**A57 Link Roads**

**9.17 Draft Statement of Common Ground  
with United Utilities**

January 2022

<b>Rule Number:</b>	Rule 8(1)(e)
<b>Planning Inspectorate Scheme Reference</b>	TR010034
<b>Application Document Reference</b>	TR010034/EXAM/9.17
<b>Author:</b>	A57 Link Roads Project Team, National Highways and Atkins

**FIGURE 13.1
SURFACE WATER RECEPTORS**

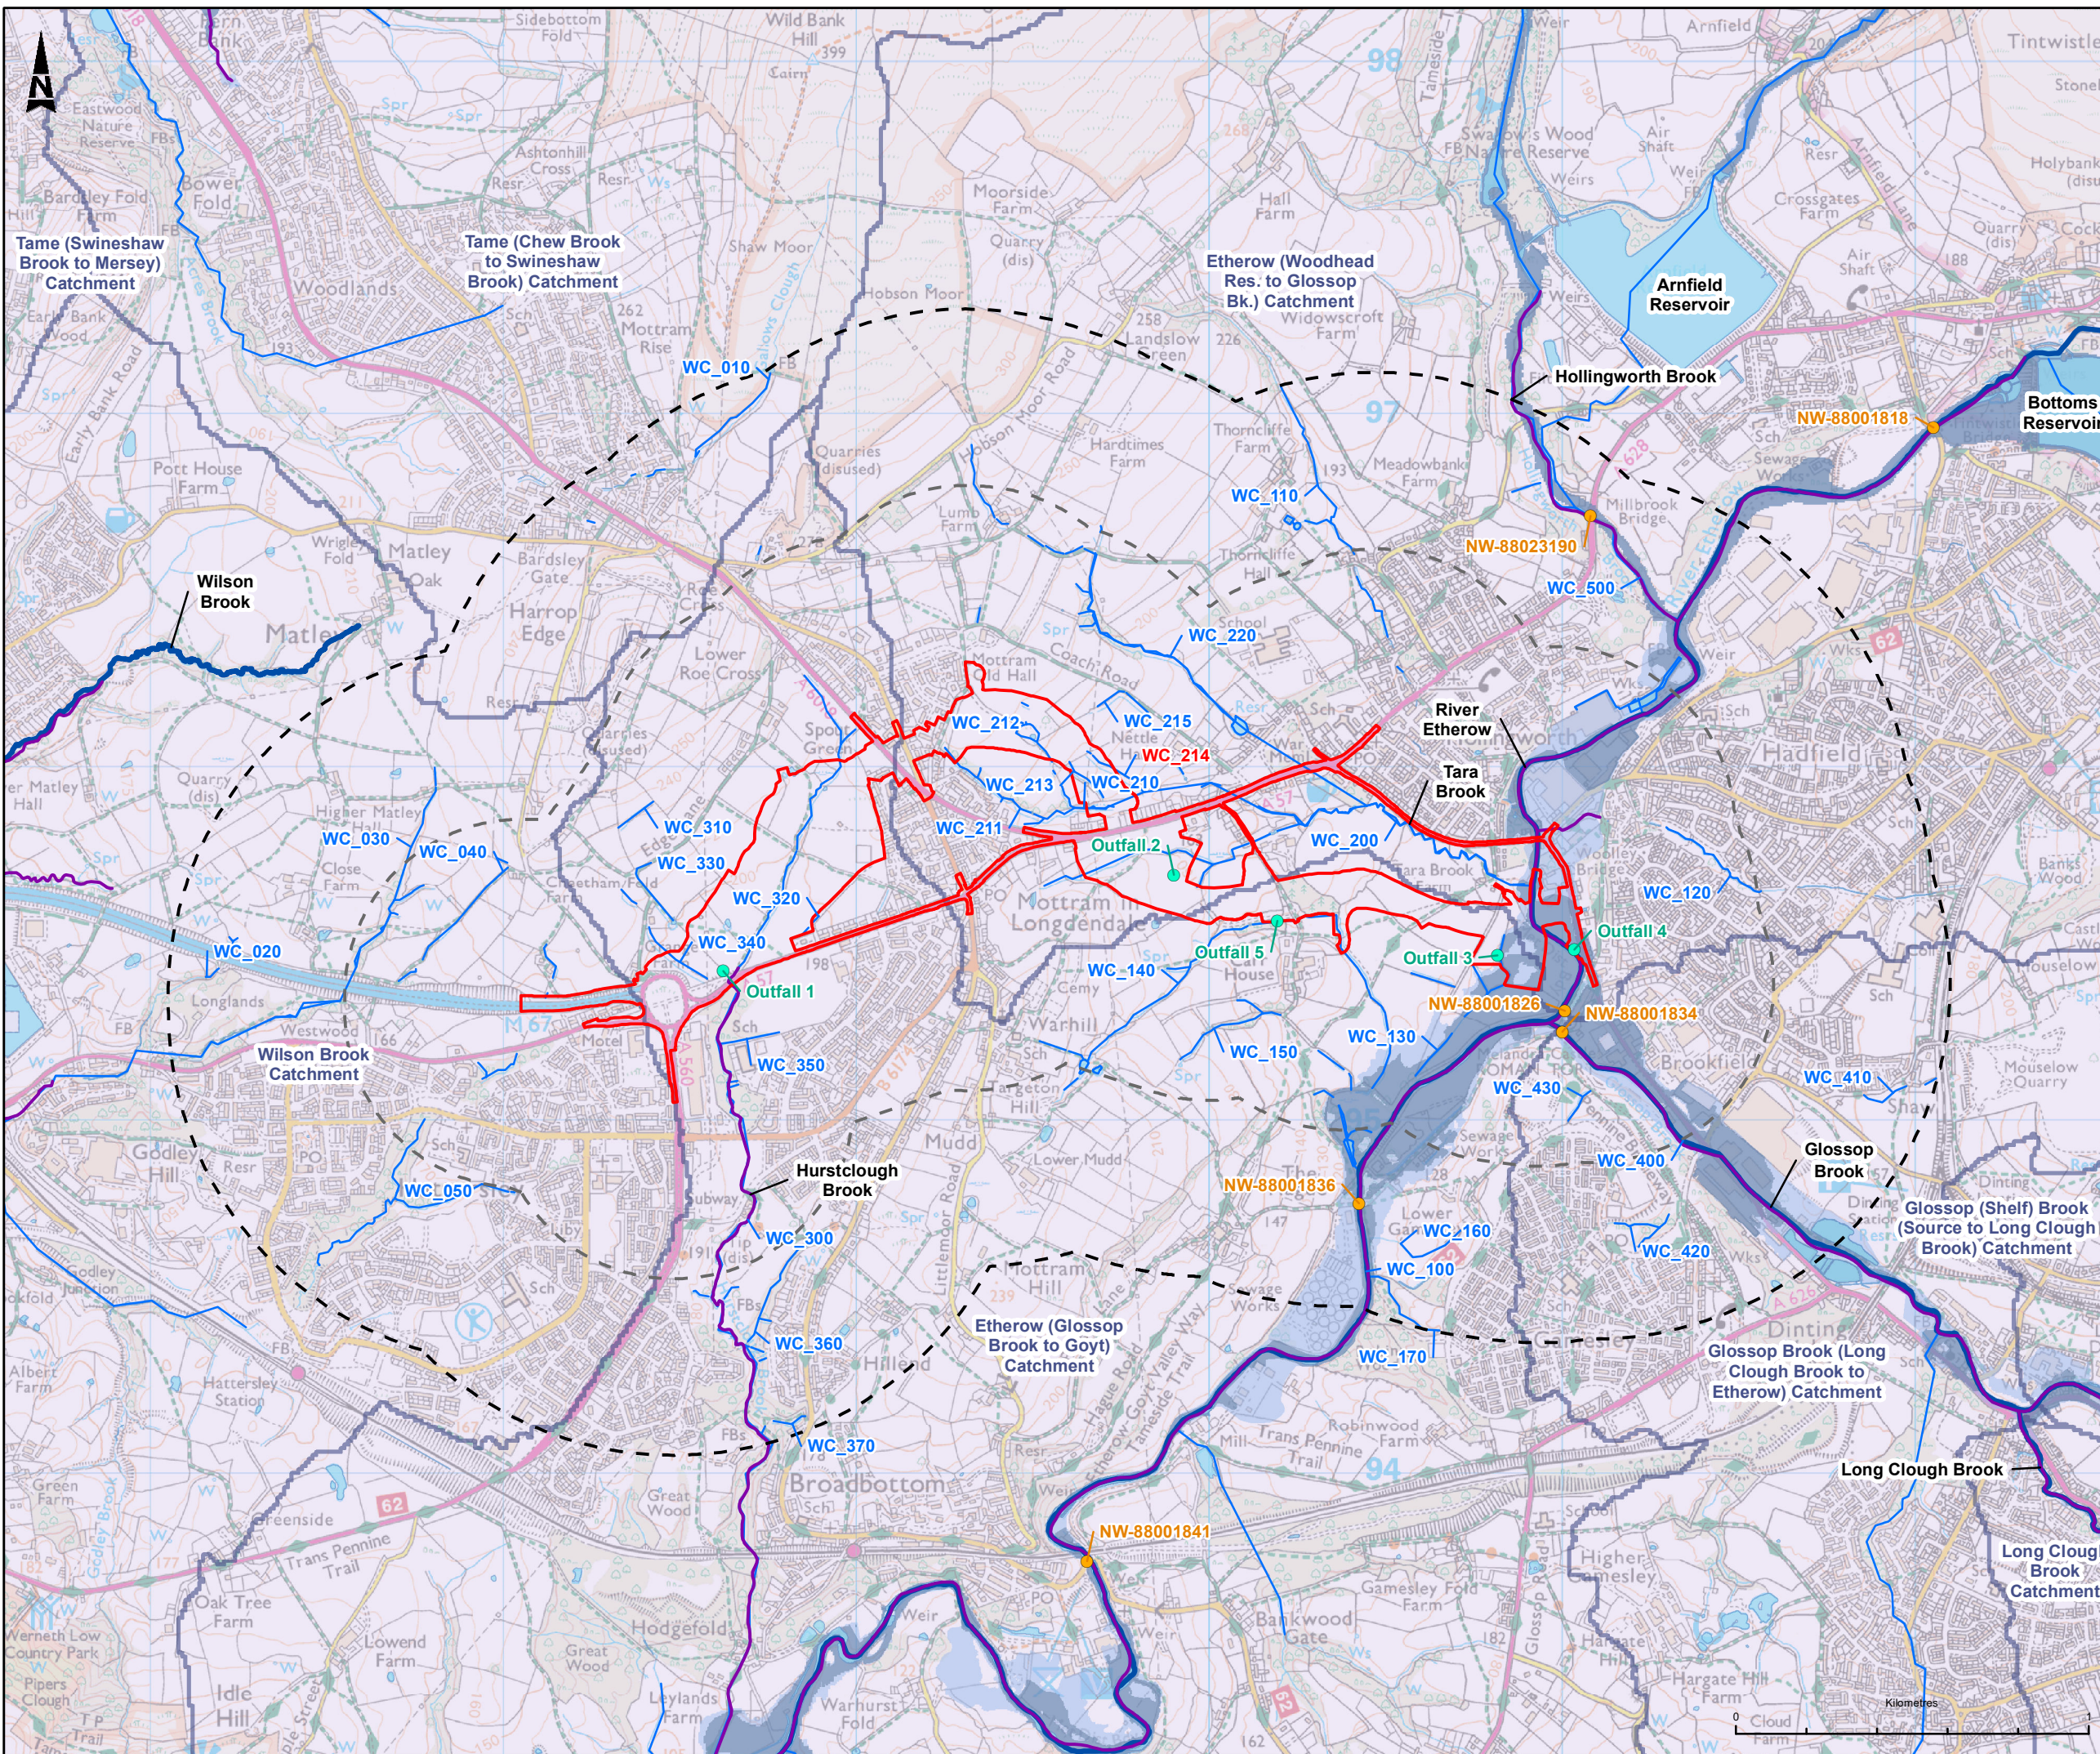
2.3	Work Plans [APP-008]	Design C3	United Utilities advised that surface water should be disposed of in a sustainable way and not get discharged into the public sewerage system.  <b>This forms a key requirement of the drainage strategy and design for the scheme</b>	Scheme drainage to be discharged into a water course (rather than UU sewers).  If temporary works discharge is required into UU sewers this is to be agreed via discharge consents.	Under discussion
